Reply to Submissions

MP 08-0148 Sandy Beach Mill

A reply with respect to all submissions
to the exhibition of the Environmental
Assessment.

Ref: SJC1184-417
Date: June 2010

**Figure 10: Site Zoning and Subdivision Layout as Proposed (source: Preferred Project Report)**

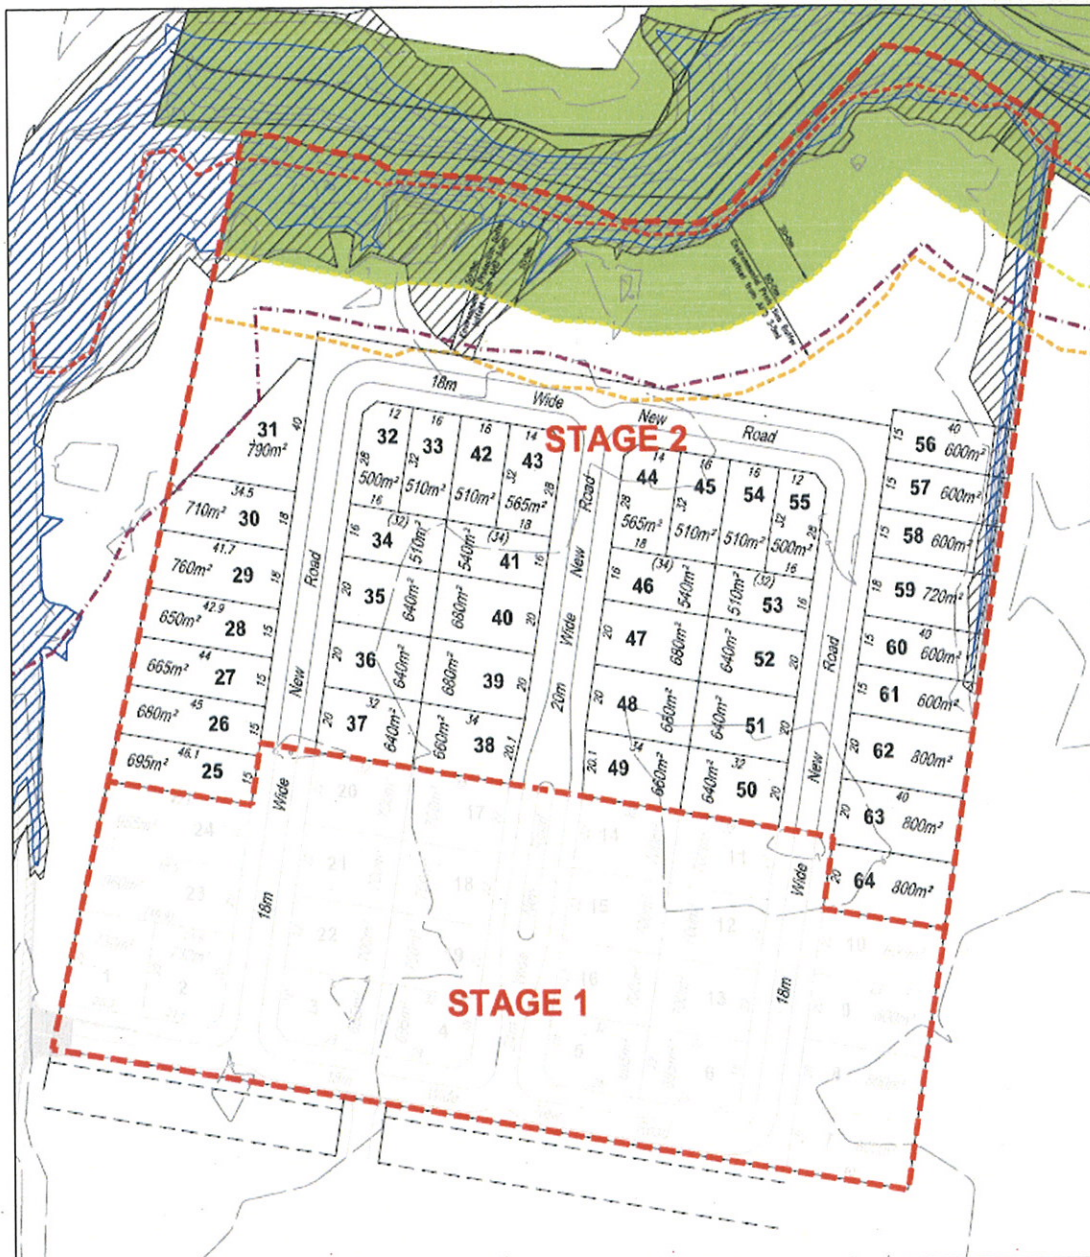
- a. The proposal involves subdivision for residential purposes within the 7A Environmental Protection (Habitat & Catchment) zone (lots 29 and 31). The Coffs Harbour City Local Environmental Plan 2000 requires a 40ha minimum lots size for lots within the 7A zone. It is recommended that the subdivision layout be redesigned to avoid the subdivision of land within the 7A zone.

The layout of the Project has been amended so as to exclude Lots 29 and 31 from the Environmental Protection 7A Habitat and Catchment zone.

Figure 13: Construction Level Thresholds (source: Holiday Coast Bushfire Solutions)

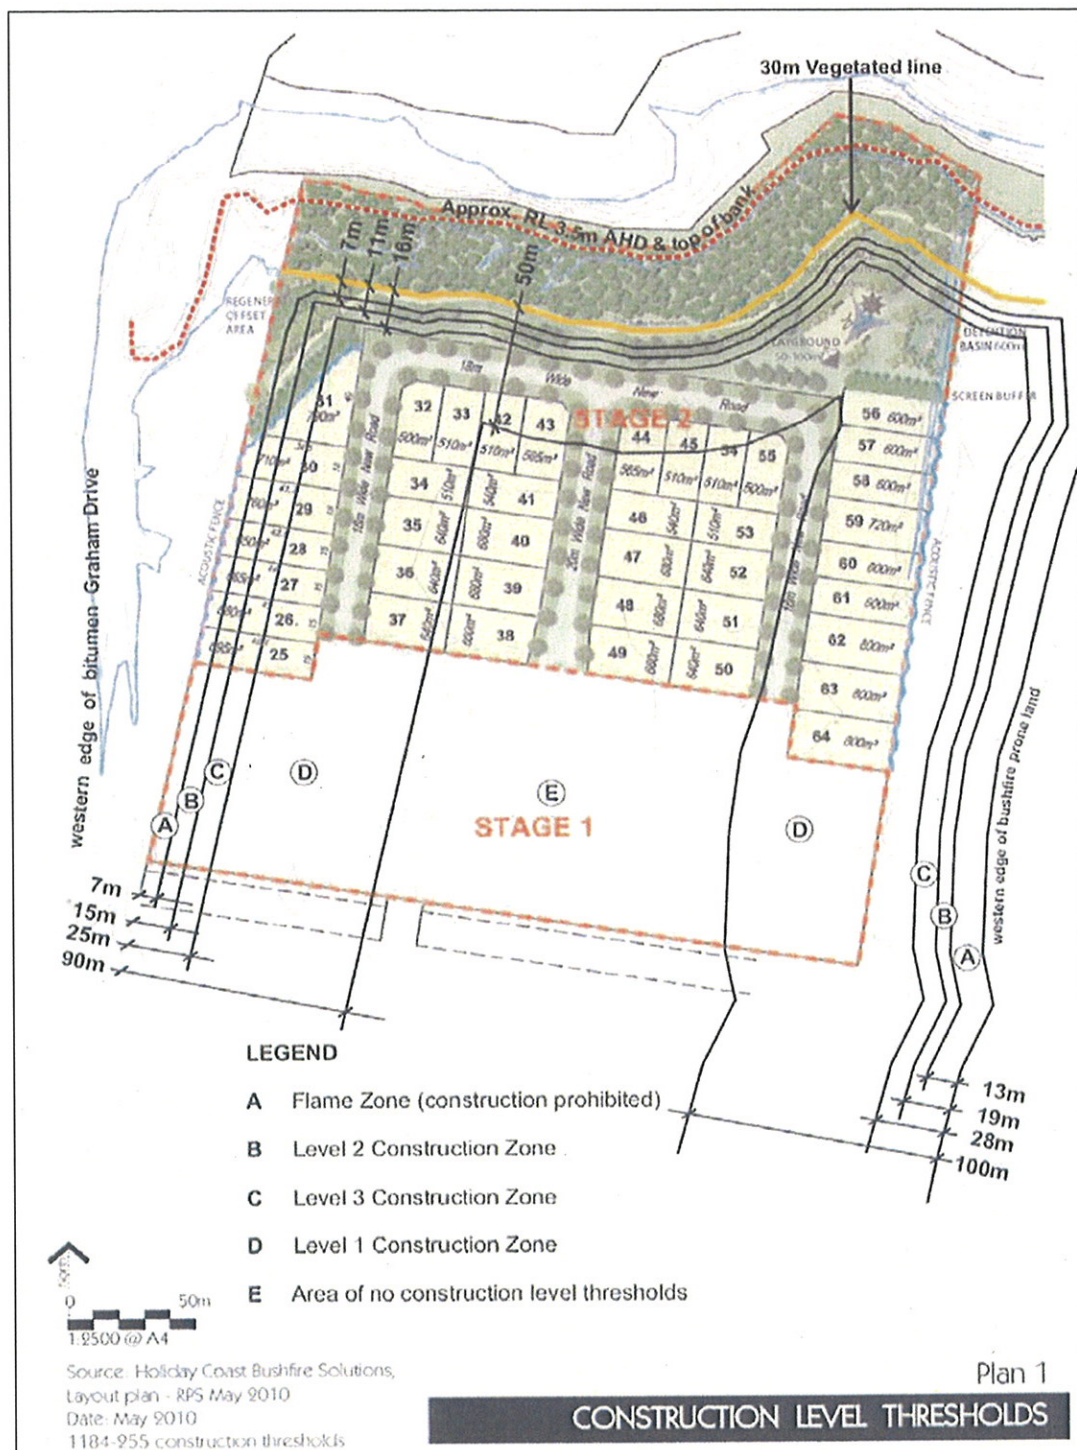
- a. The Statement of Commitments (SoCs) should be more specific in relation to management and mitigation measures. Level 1 construction levels are required for lots 25 to 31 inclusive. and 42 to 51 inclusive -this should be outlined in the SoCs.

An amended construction level plan has been produced for the Project. This however, is not referenced in the Modified SoCs, given that construction levels can be determined at the time development applications are lodged for dwelling houses. As is apparent from the recent changes to Planning for Bushfire Protection 2006, there is little utility in determining a construction level which may be subject to change. Notwithstanding, the amended construction level plan shows that all of the proposed allotments are capable of accommodating dwelling houses, having regard to the threat of bushfire.

It should be noted that the amended construction level plan is based around discussions with CHCC regarding the manner and extent of revegetation in the 50m riparian buffer, which in turn influences the construction levels for some of the proposed allotments. The extent and manner of revegetation is ultimately to be determined following approval of a Landscaping Plan; a SoC requiring an amended Plan has been added to the Modified SoCs in **Annexure A**. Notwithstanding, CHCC has indicated that generally, the first 20m from top of bank is to be heavily vegetated, representative of vegetation located east and west of the site, the next 10m is to be less heavily vegetated, while the final 20m is to comprise isolated trees and shrubs with a turfed understorey.
